I have reviewed the Application for the Richard (SP-07-15), Sage (SP-07-12), Range (SP-07-13), Rowan (SP-07-21) Short Plats. I provide review of proposed development and construction for Kittitas County Fire District 2. The Fire District has no code enforcement authority so my input is, for the most part, informational only.

TO: Mary Rill, Community Development Services
FROM: Christina Wollman, Planner II *W*
DATE: March 7, 2007
SUBJECT: Wilson, Range, Sage and Richard Short Plats

We have received the proposed Richard Short Plat, located in Section 32, Township 19, Range 18, off of Lower Green Canyon Road. We have also received the \$376.88 plat submission fee (receipt #49745 & 49746).

RICHARD SHORT PLAT

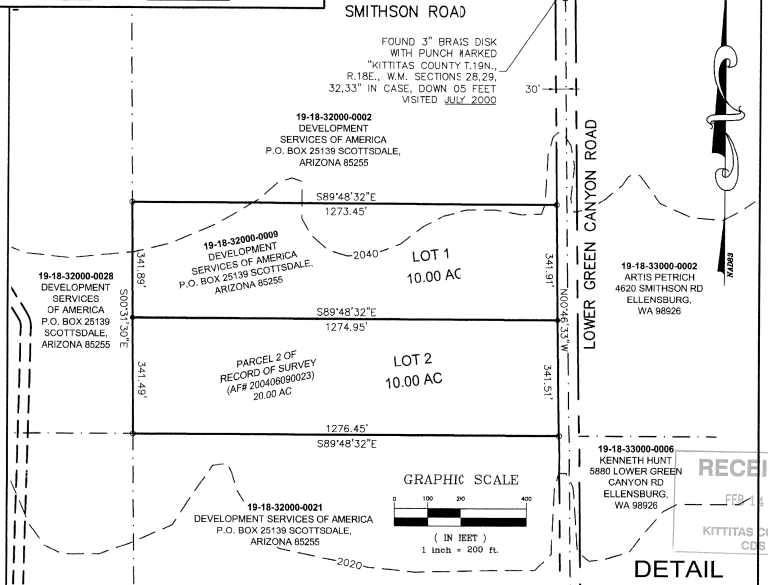
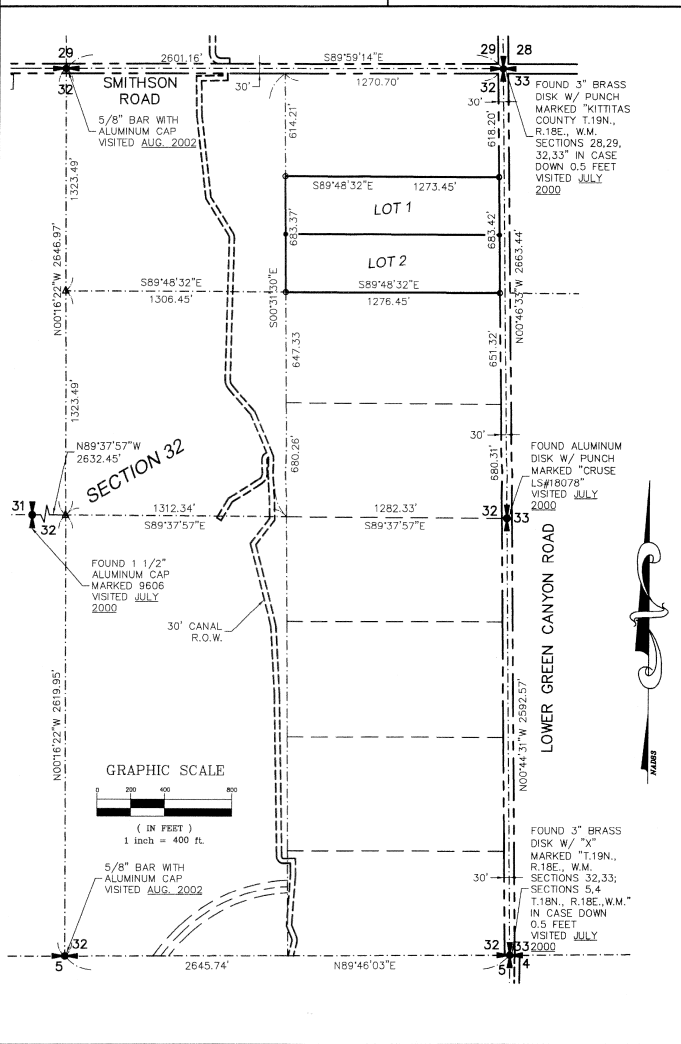
4. Driveway Access for Range Short Plat: Lots 1 and 2 will be accessed by the 30' easement shown on the plat. At a minimum, a joint-use driveway must be constructed at this location. Kittitas County Road Standards for this driveway type are shown above in comment #3.

5. Existing Features: It appears that there is an existing home site on Lot 2 of the Wilson Short Plat. All existing features, including existing accesses, shall be shown on the face of each plat.

6. Plat Notes: Plat notes for each short plat shall reflect the following:
- a. Plat note #3 is incorrect and shall be removed.
 - b. Maintenance of the access is the responsibility of the property owners who benefit from its use.
